**M54 to M6 Link Road
TR010054**

**8.8 LIU(E) Draft Statement of Common
Ground with Mark Commins & Tracey
Commins**

February 2021

This Statement of Common Ground has been prepared and agreed by (1) Highways England Company Limited and (2) Mark Commins & Tracey Commins.

Drawing Title
**FIGURE 11.1
 NOISE LOCATION PLAN**

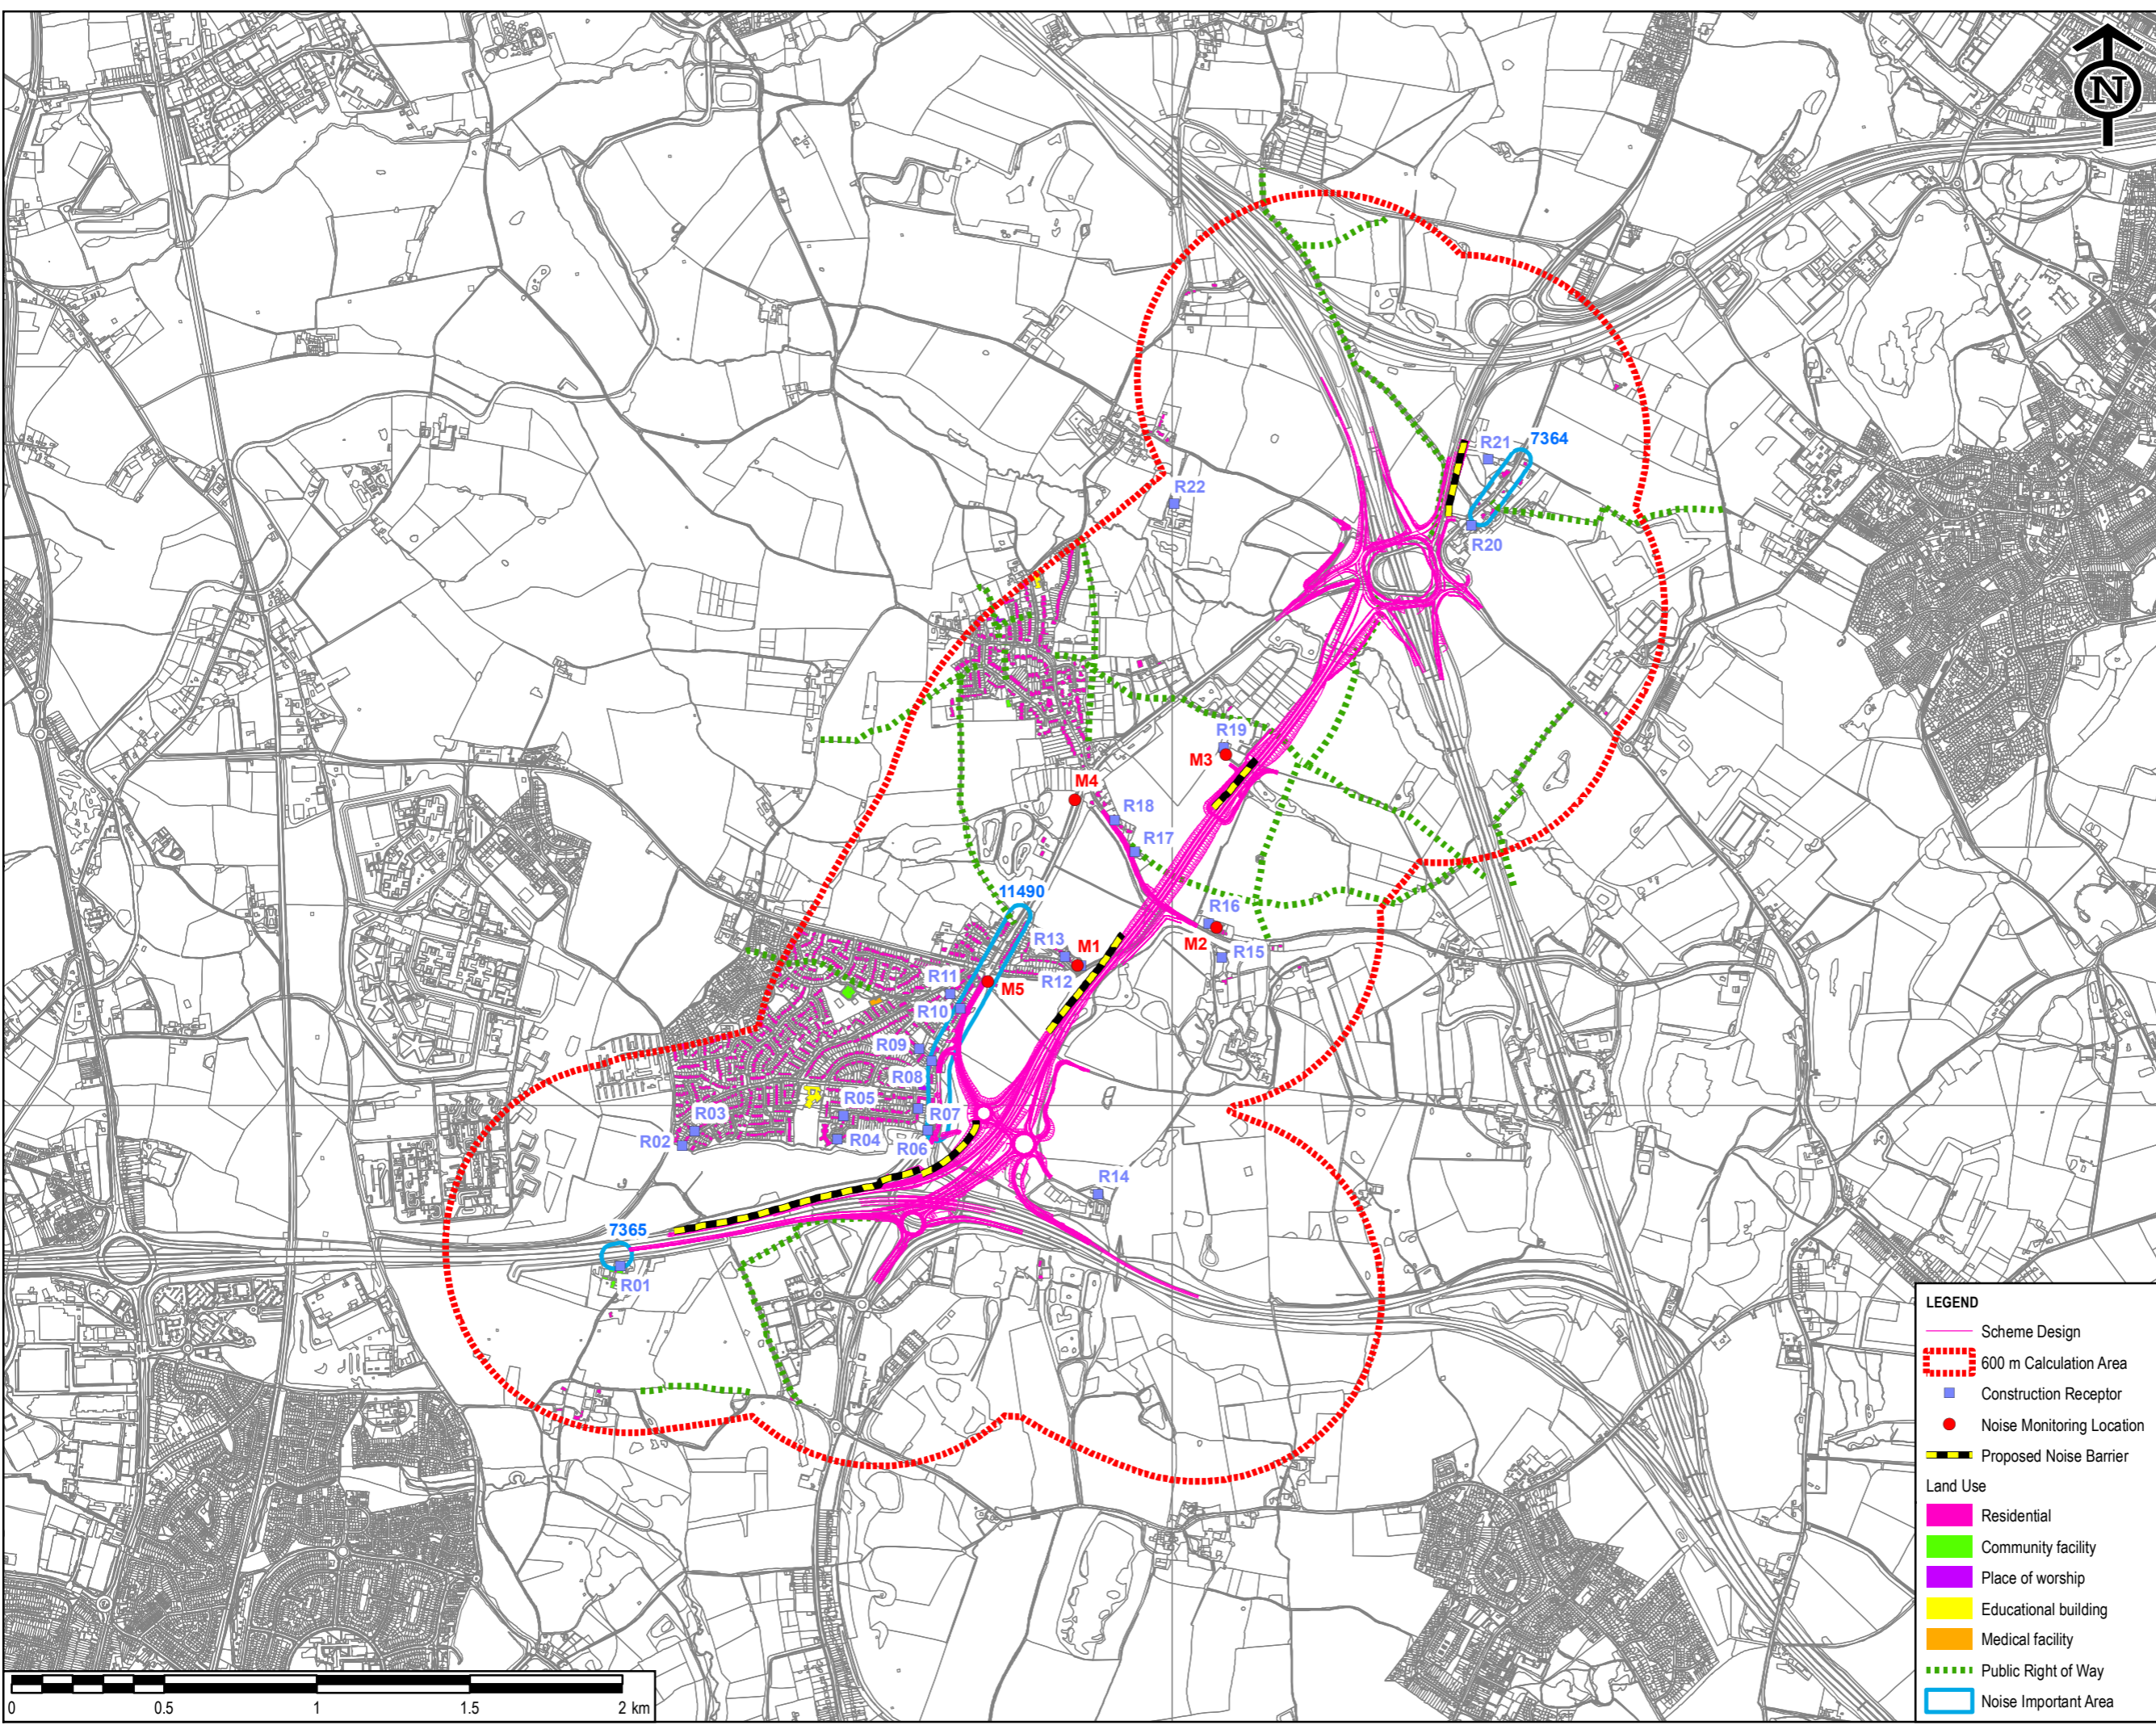
Noise monitoring	Question raised why noise monitoring surveys were not conducted from the club house	Noise monitoring has been undertaken as part of the Environmental Impact Assessment and the results are reported in Figure 11.1 of the Environmental Statement [TR010054/APP/6.2]. The noise monitoring is used to develop an understanding of the general noise climate in the vicinity of the Scheme, and as part of a validation exercise for the prediction model; it is not	Agreed (To be confirmed by landowners)	High

Issue	Landowner comment	Highways England Response	Status	Agreement likely ¹
		<p>used to establish baseline conditions for individual receptors. The traffic noise levels and any subsequent change in the traffic noise levels as a result of the Scheme are then predicted using the model. In order to quantify traffic noise, Highways England would normally want to avoid siting monitoring equipment near specific known noise sources which might distort the numeric results (e.g. a building which may generate entertainment noise).</p>		
Air quality impacts	Air quality assessment at Brookfield Farm	<p>Based on the affected road network, sufficient monitoring data is available from Highways England and local authority sources to confirm the model performance, without the need for further monitoring at this stage of the design. The assessment on air quality in Chapter 5 of the Environmental Statement [TR010054/APP/6.1] demonstrates that no properties will experience air pollution levels above national air quality objective values post construction as a result of the Scheme. The significant reduction in traffic along the A460 will potentially enable future improvements to the road for pedestrians and cyclists, improve the environment around the road and may contribute positively to the identity of these villages along the route.</p>	Agreed (To be confirmed by landowners)	High
